Mike Ovenden | Associate Planning Consultant | for Brentwood Borough Council

**Application by Highways England for the M25 Junction 28 Project
The Examining Authority's Further Written Questions and requests for information (WQ2) Issued on Thursday 25 March 2021**

The following table sets out the Examining Authority's (ExA) further written questions and requests for information – WQ2 – directed to Brentwood Borough Council. Responses to those questions are set out **in blue text** in the table below.

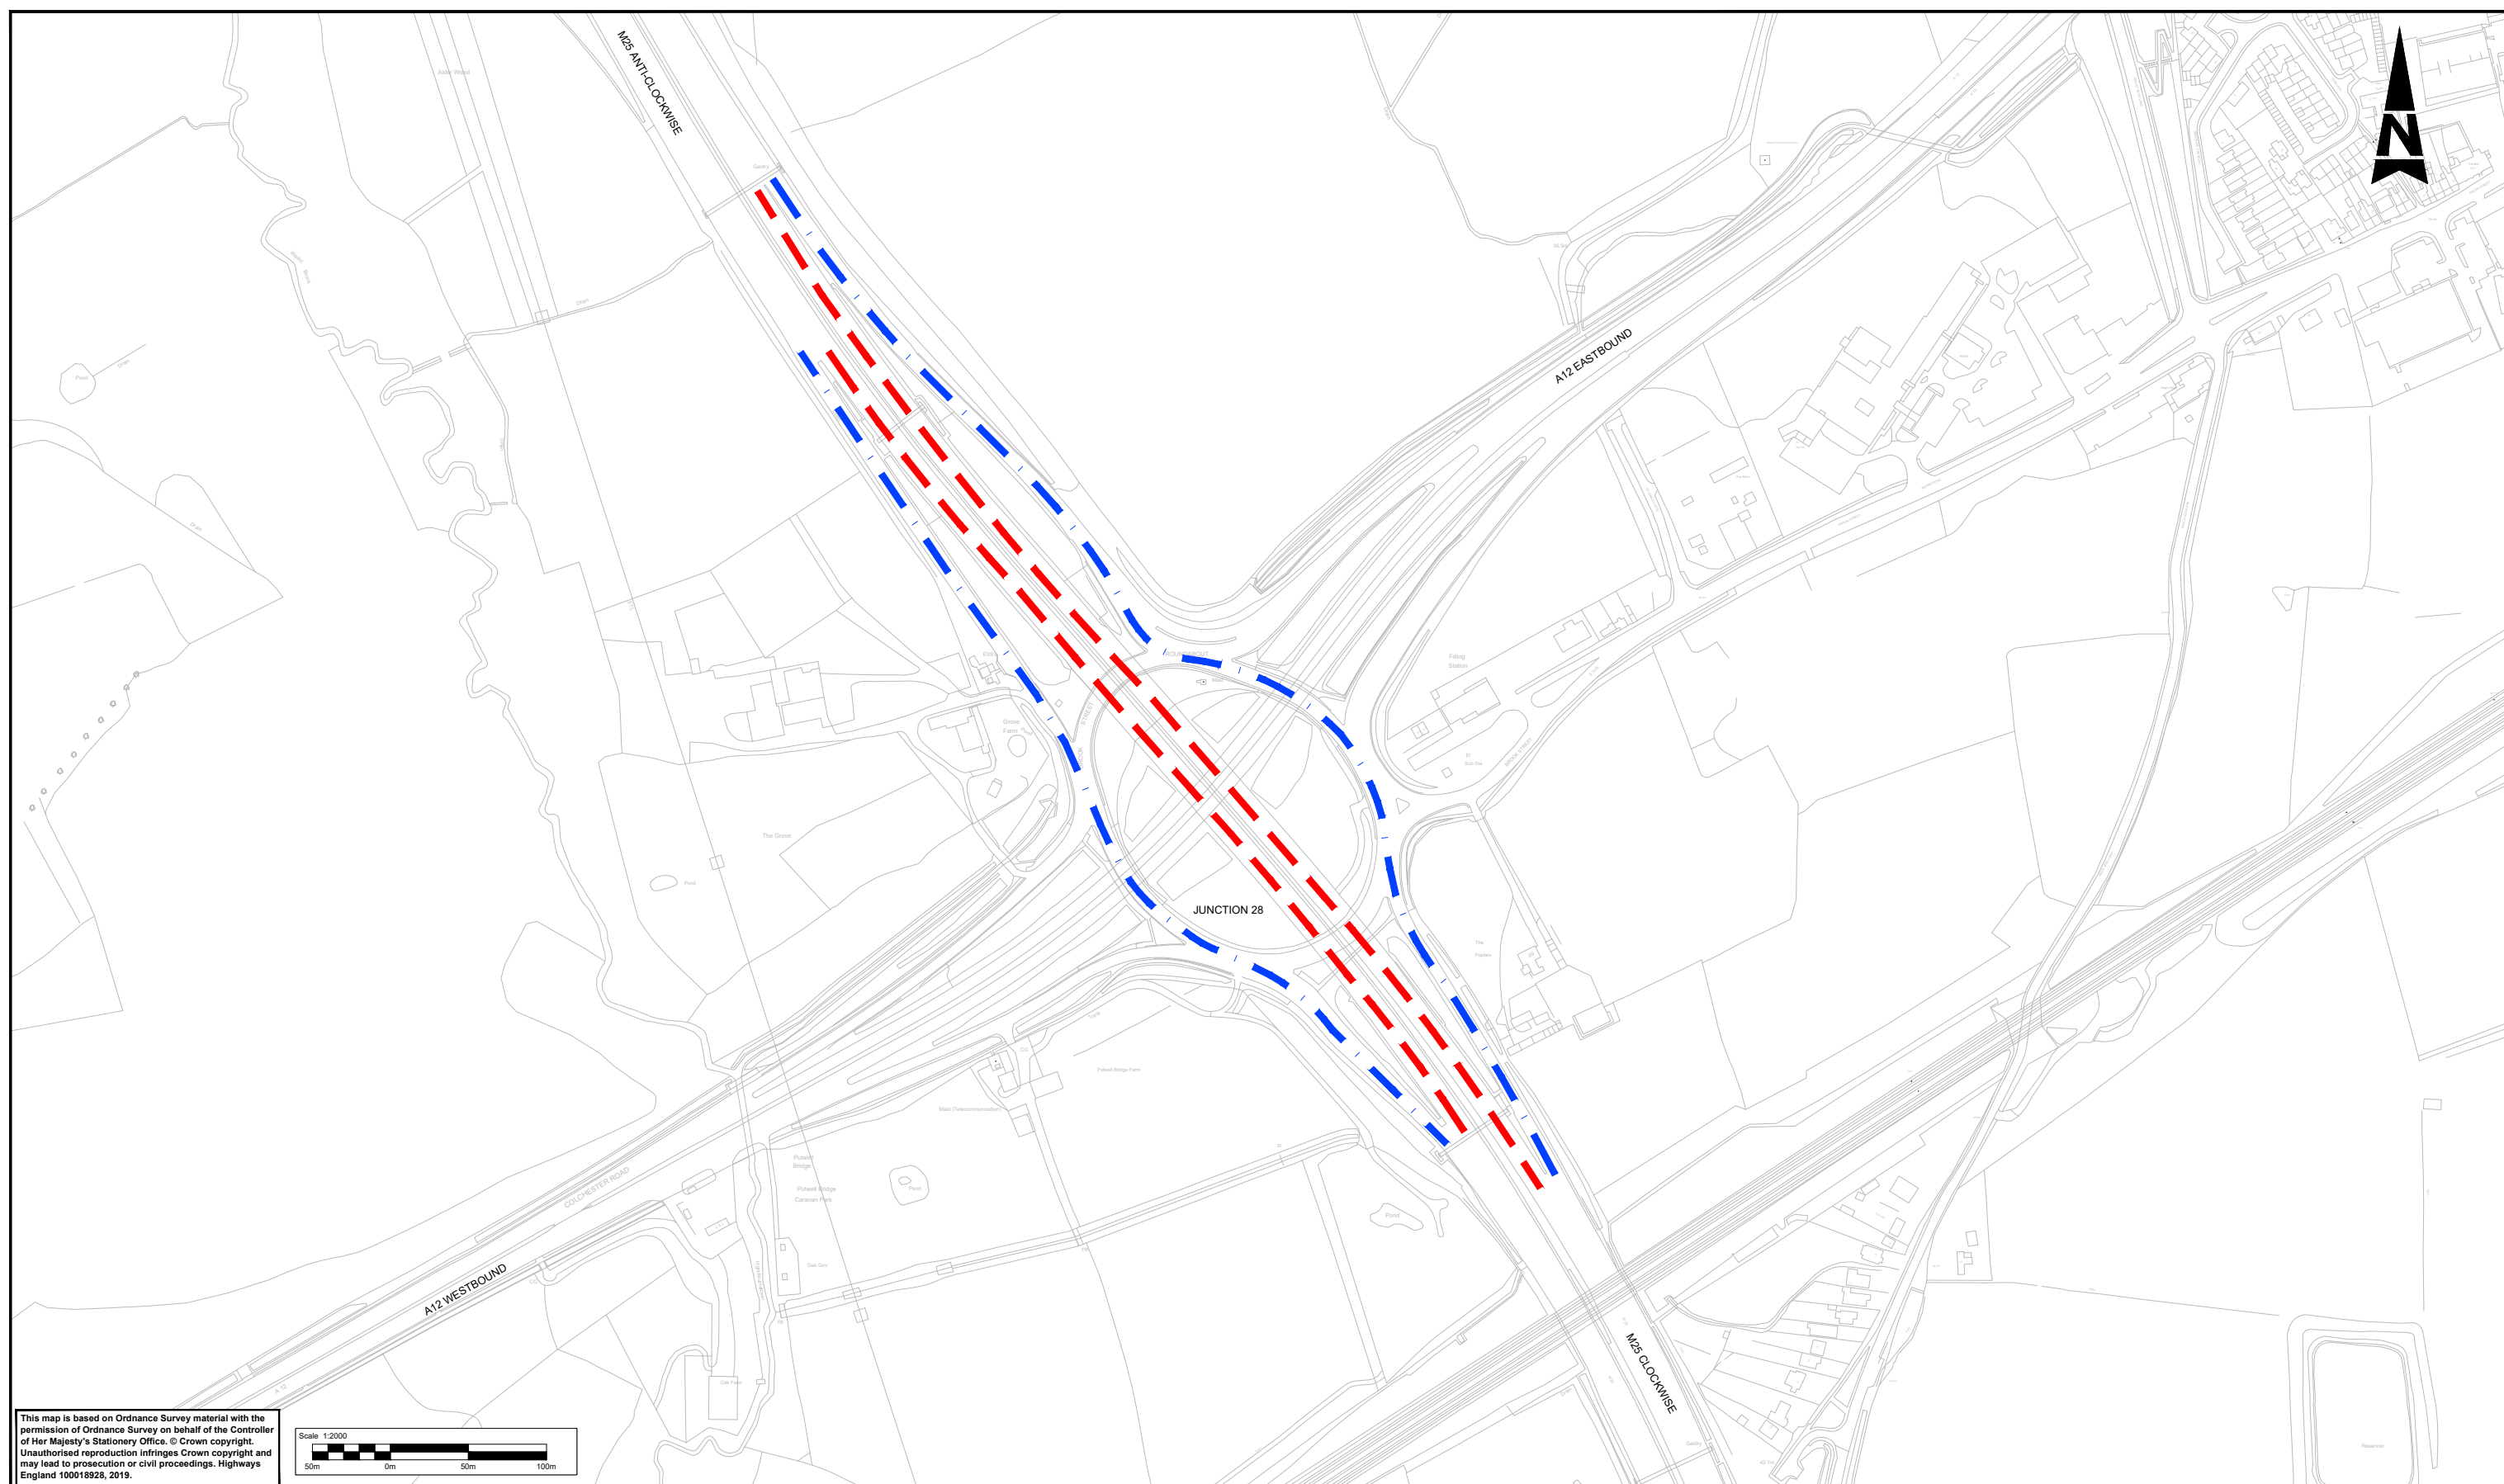
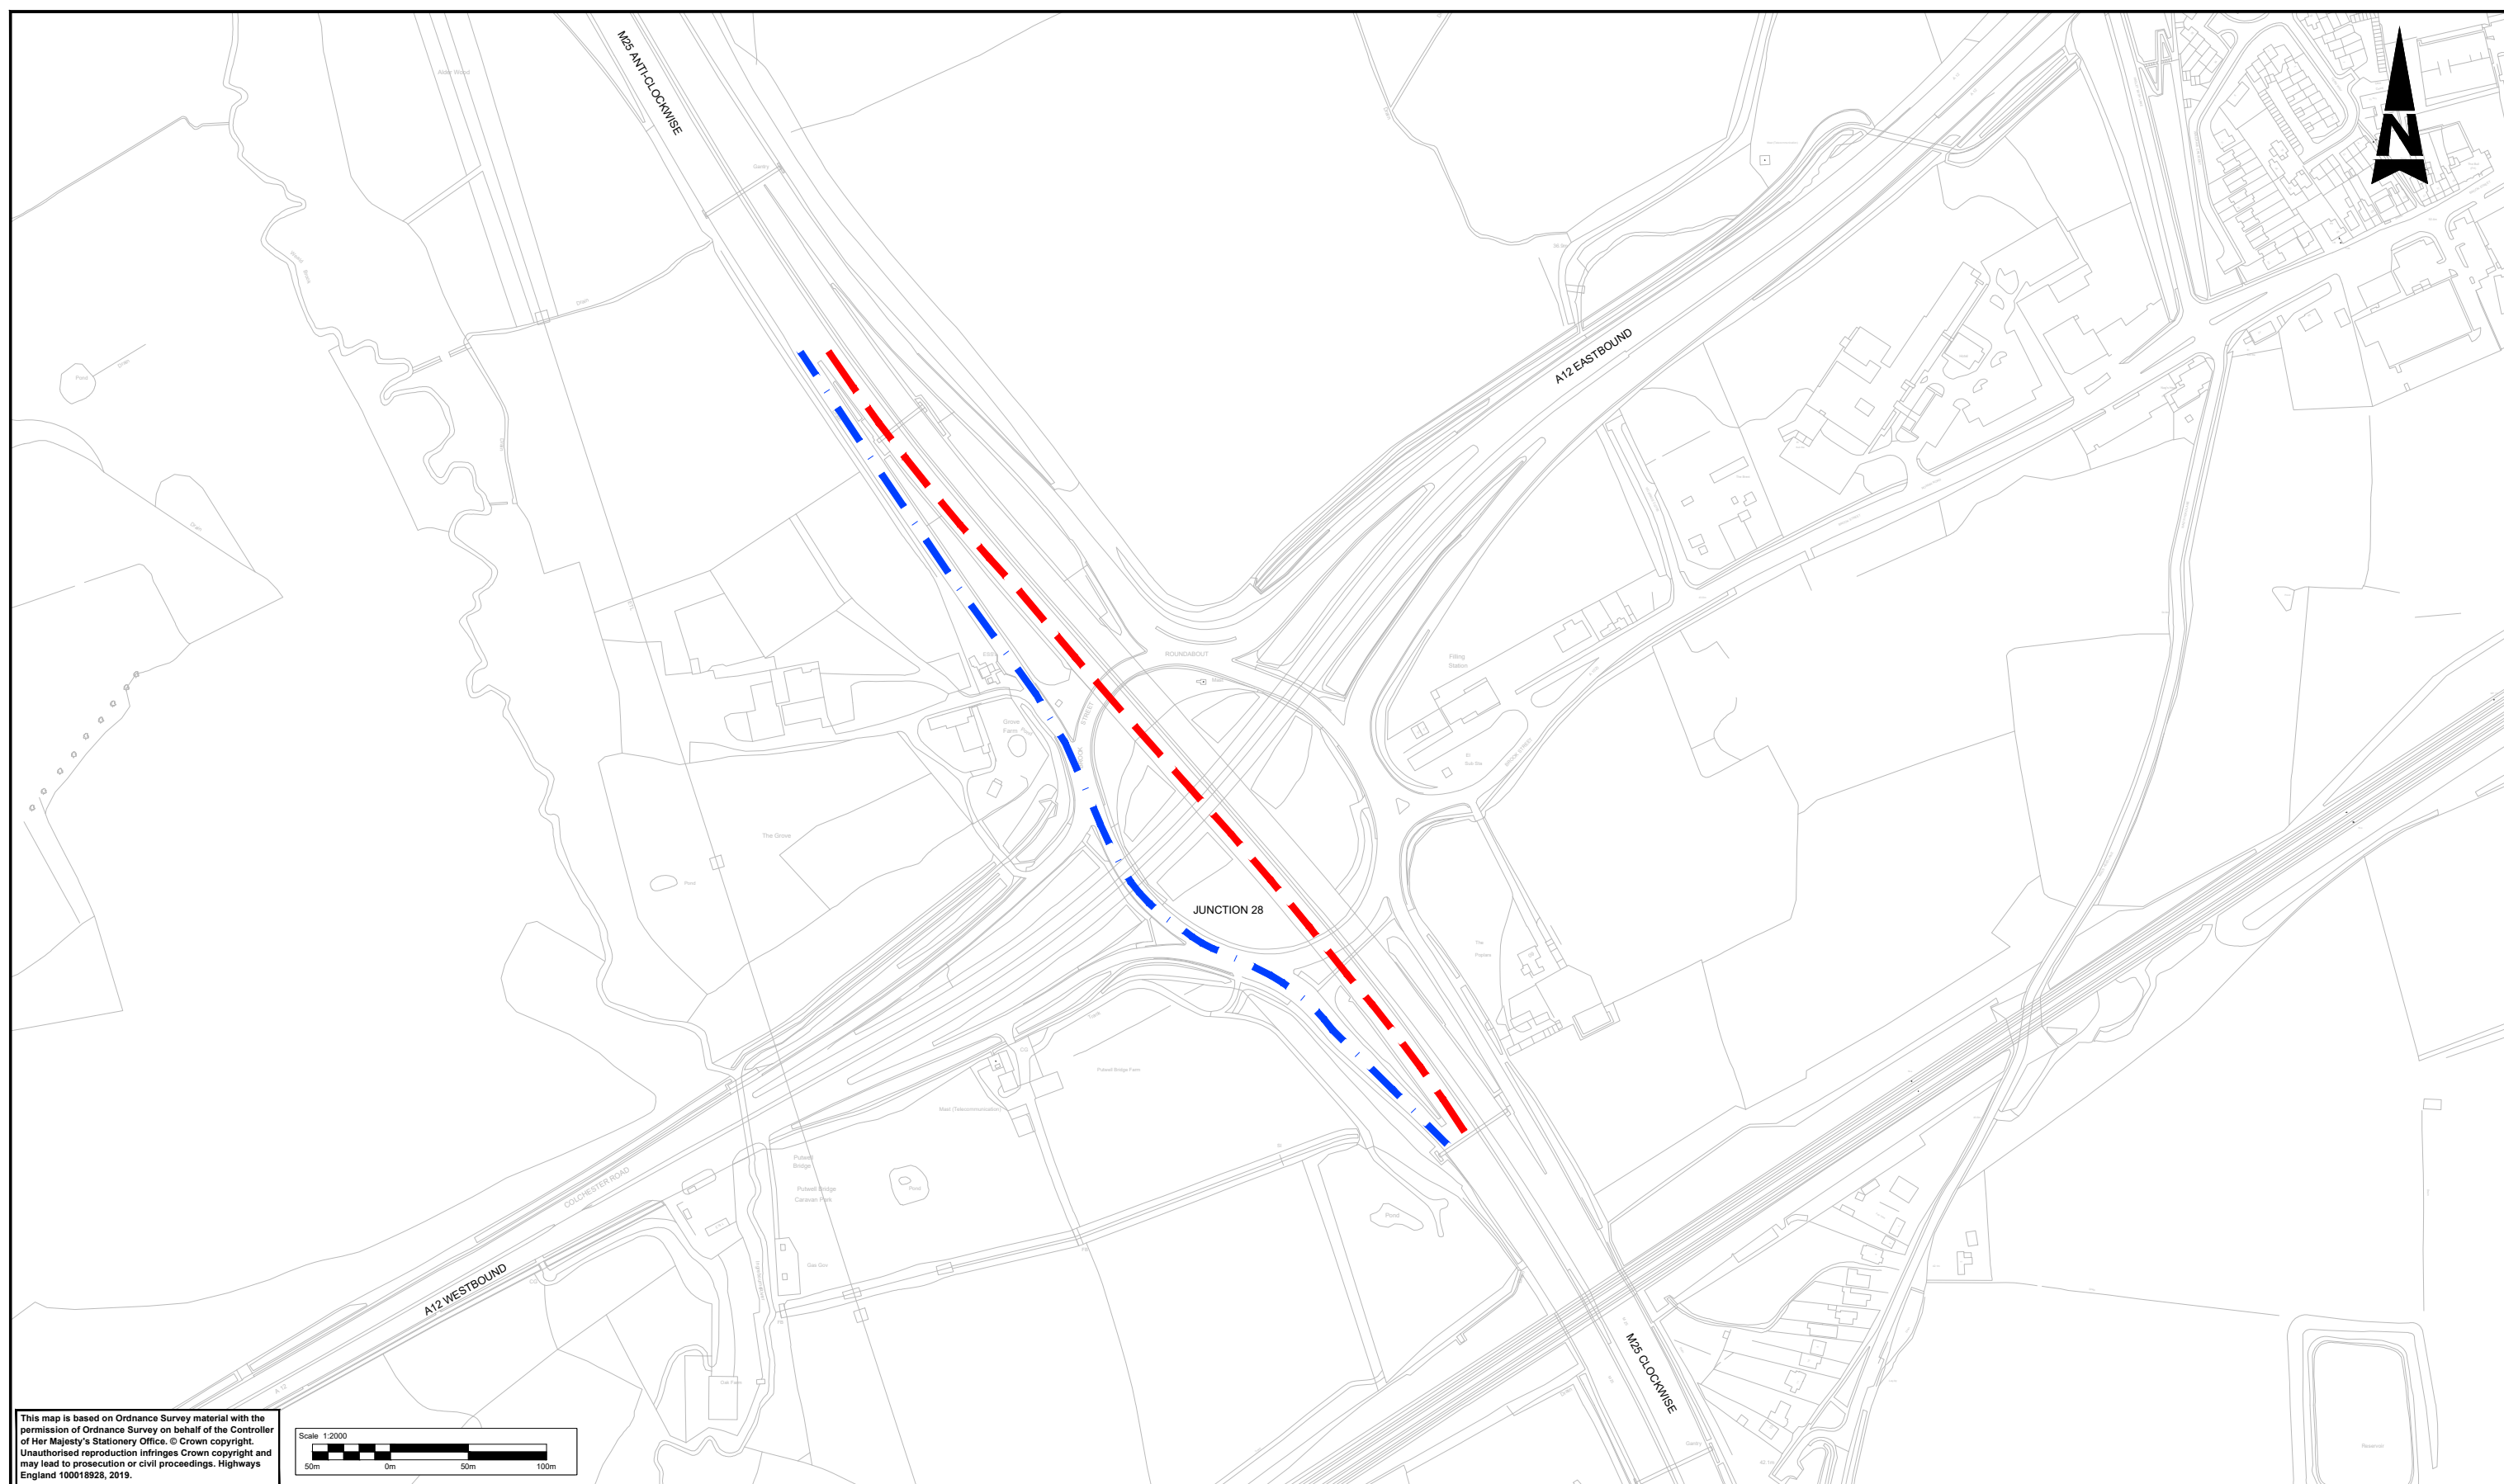
<p>is not the case indicate where the diversion caused by such a closure is described in the outline TMP.</p> <p>For Interested Parties: ii) Comment on the outline TMP.</p> <p>It appears that the closures to the M25 clockwise off slip at J28 are to allow the gantry works (Work 9) to be undertaken. Confirmation would be welcome.</p>
--	--	--
